**Canal &
River Trust**

Your Ref 2025/92689

Proposal: Discharge of details reserved by conditions 3 (Construction Environmental Management Plan), 7 (electric car charging), 8 (storm event assessment), 9 (Phase I study), 10 (Phase II Intrusive Site Investigation Report), 11 (Remediation Strategy), 12 (compliance with Remediation Strategy), 13 (Verification Report) and 15 (waste storage and collection) of previous permission 2024/91828 for demolition of existing hotel restaurant and erection of additional hotel bedrooms with breakfast room and alterations to the car park and associated works

Location: Premier Inn, St. Andrew's Road, Huddersfield

Figure 1 Site Set-Up Plan

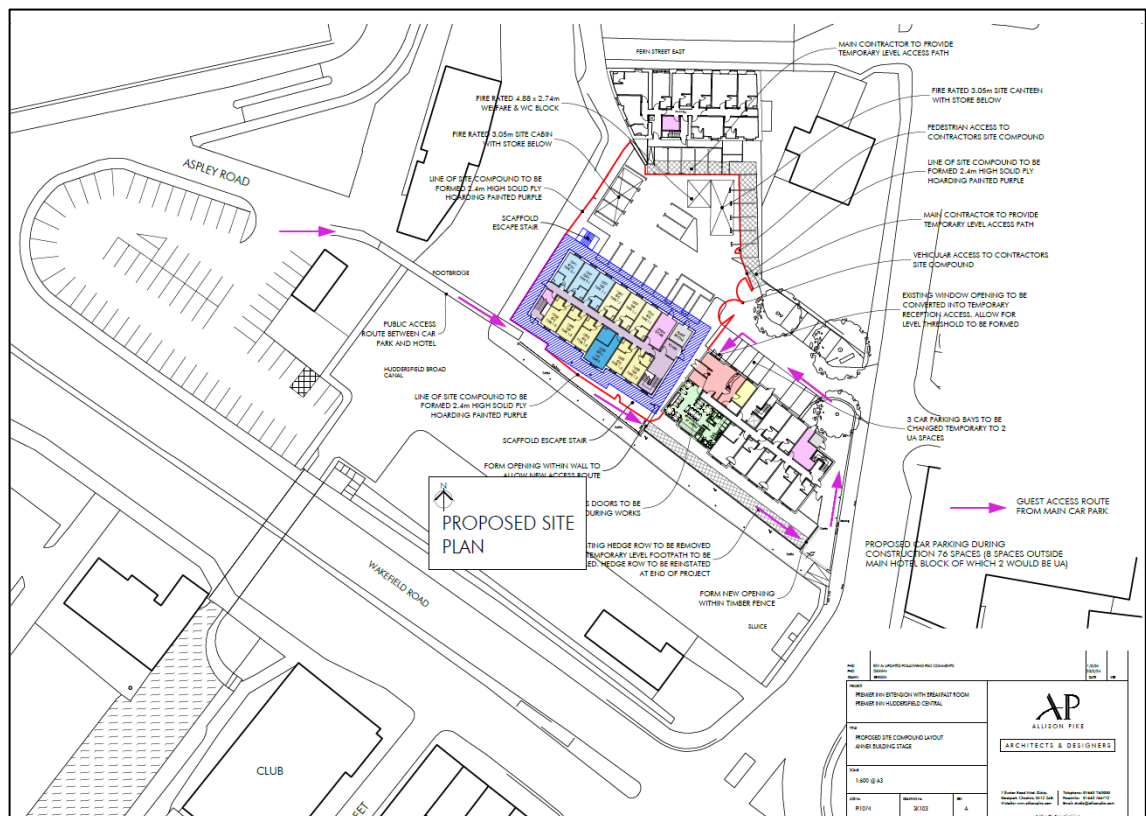
With regards to the protection of the canal from structural damage, we request that measures should be identified in the CEMP to ensure that no plant or vehicles will be sited closer to the canal walls than 2m. Vibration

and movement monitoring of the canal walls should also be specified to ensure that they are appropriately protected during any excavation or piling work (if required).
